December 10, 2007

RE: Residence Inn by Marriott  
Hancock Street and Fore Street  
City of Portland, ME

This letter is in response to your email dated December 6, 2007. Please see below your questions with the responses.

DRAWING NO.
A3.1

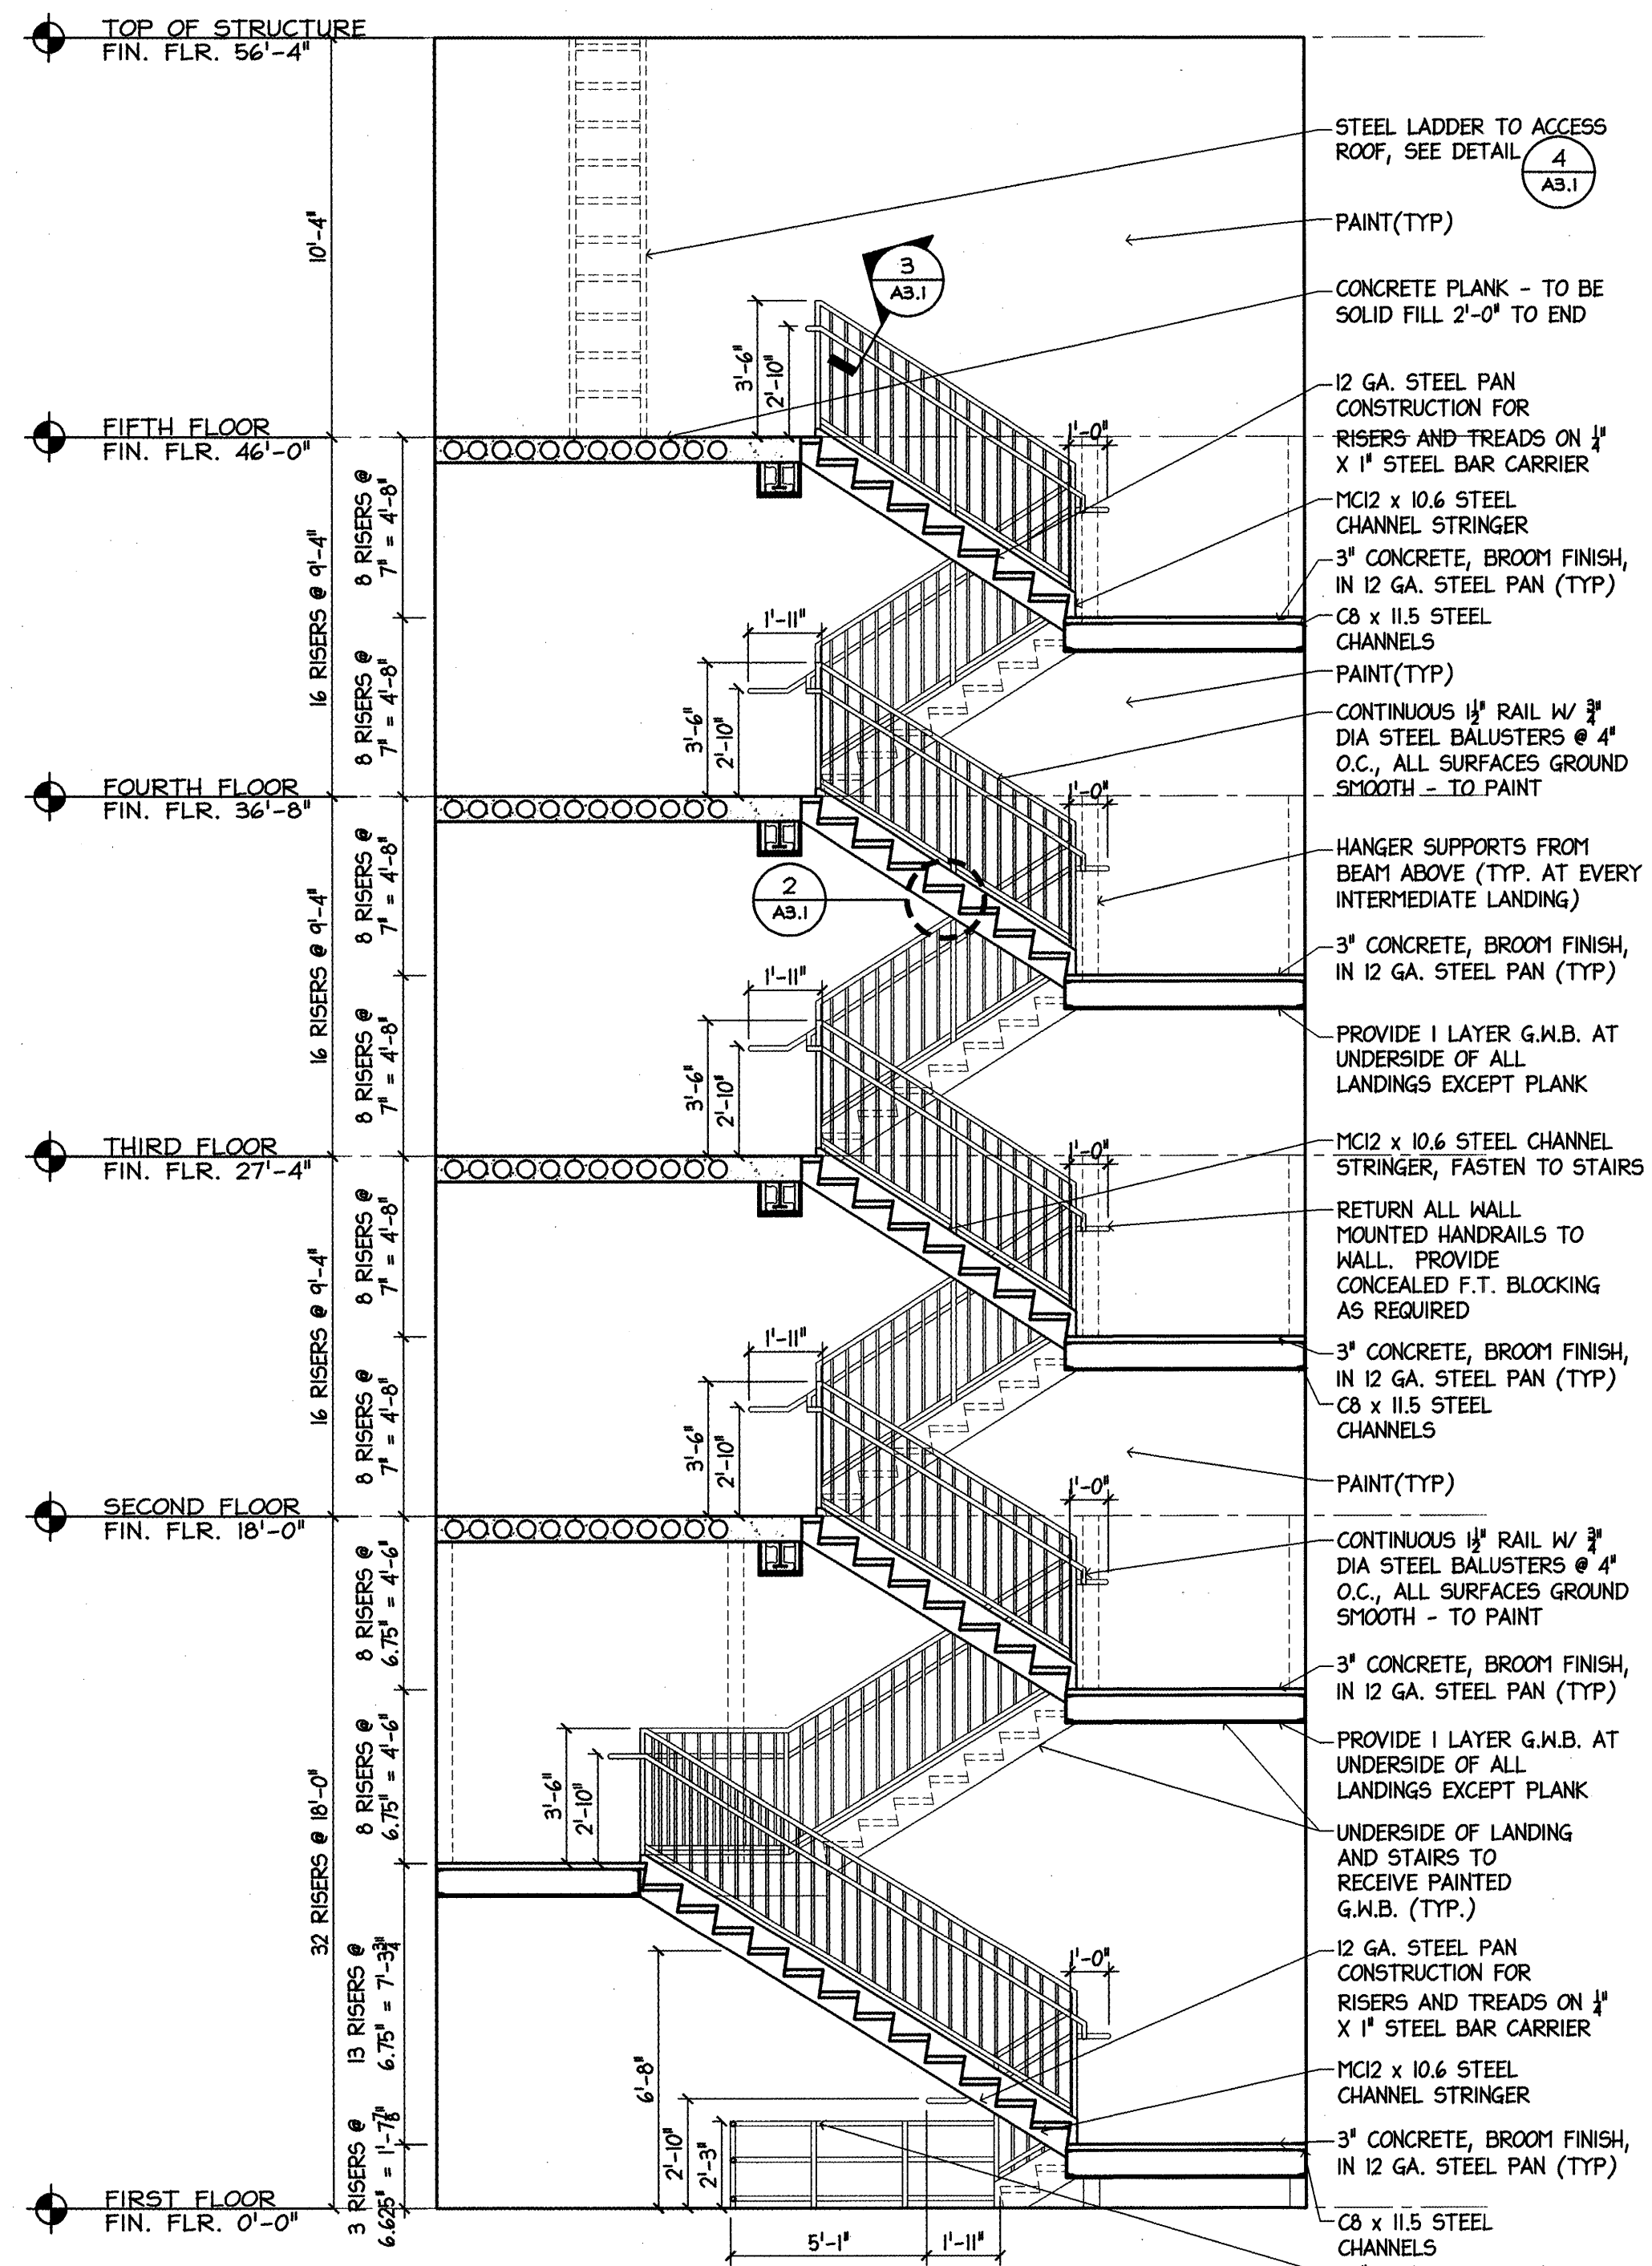
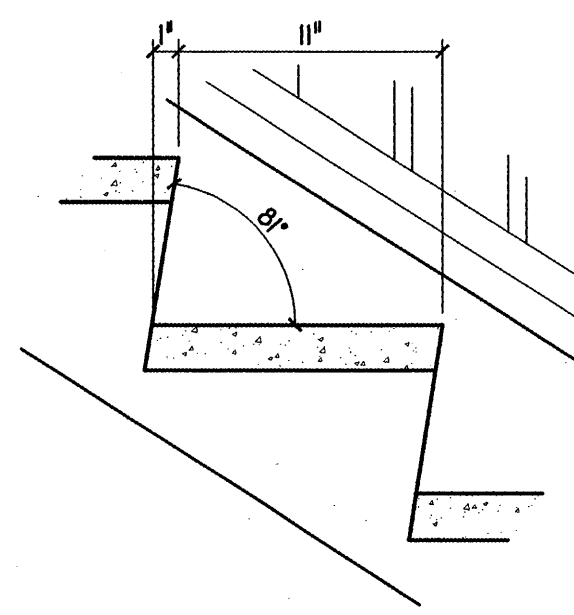
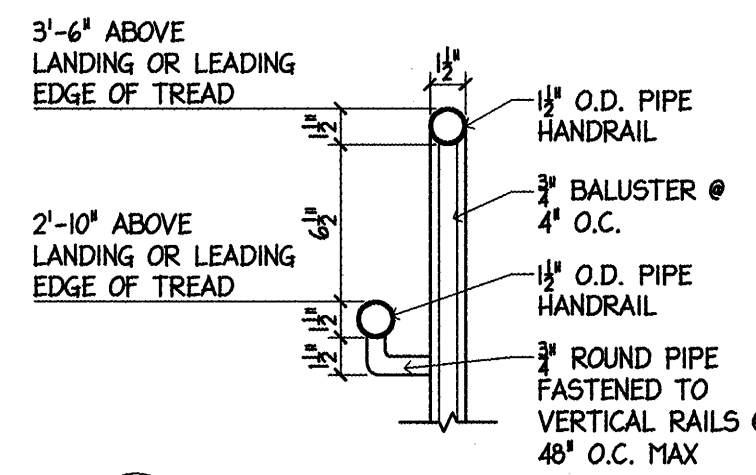
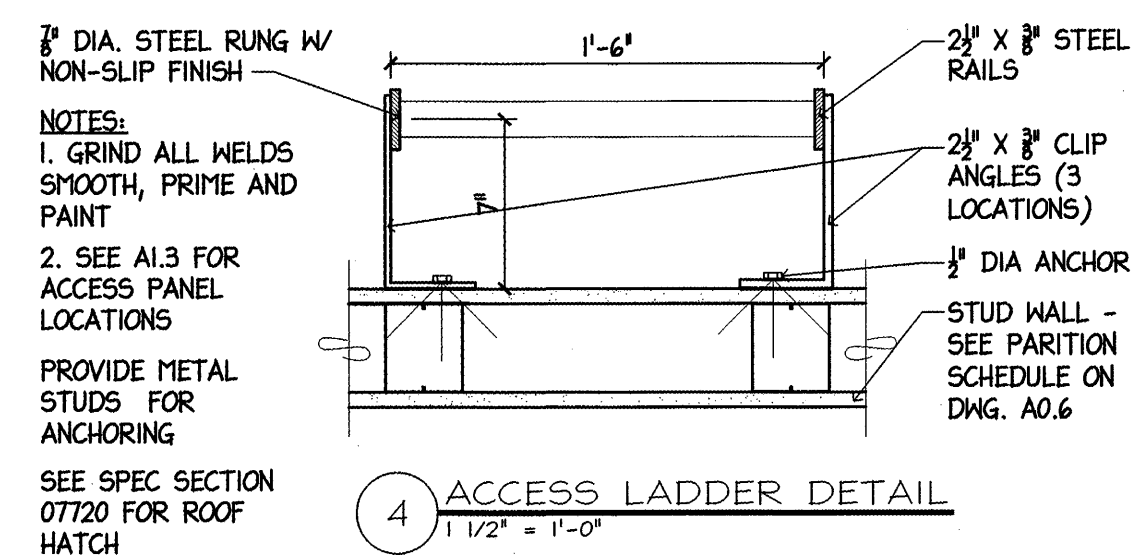
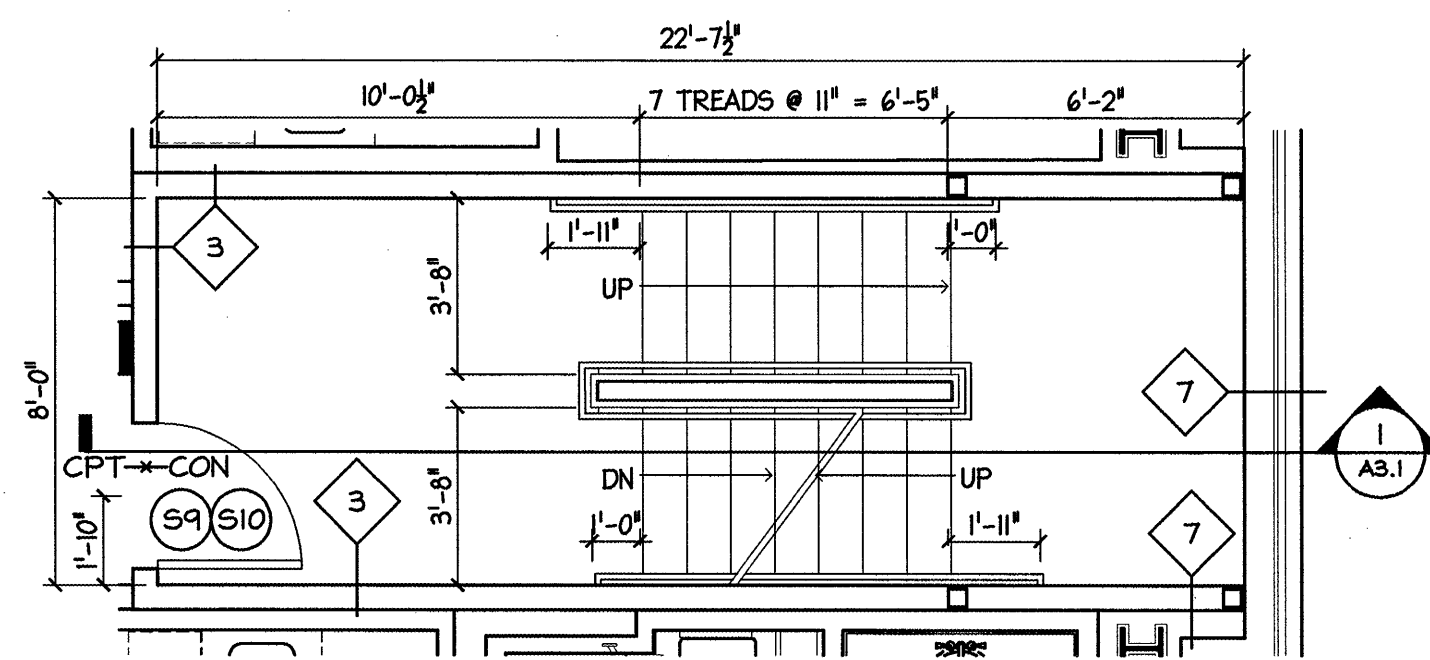
An additional item that was discussed at our meeting was the alternating stairs for access to the roof. This has been added to the drawings, please see attached sheet A3.1.
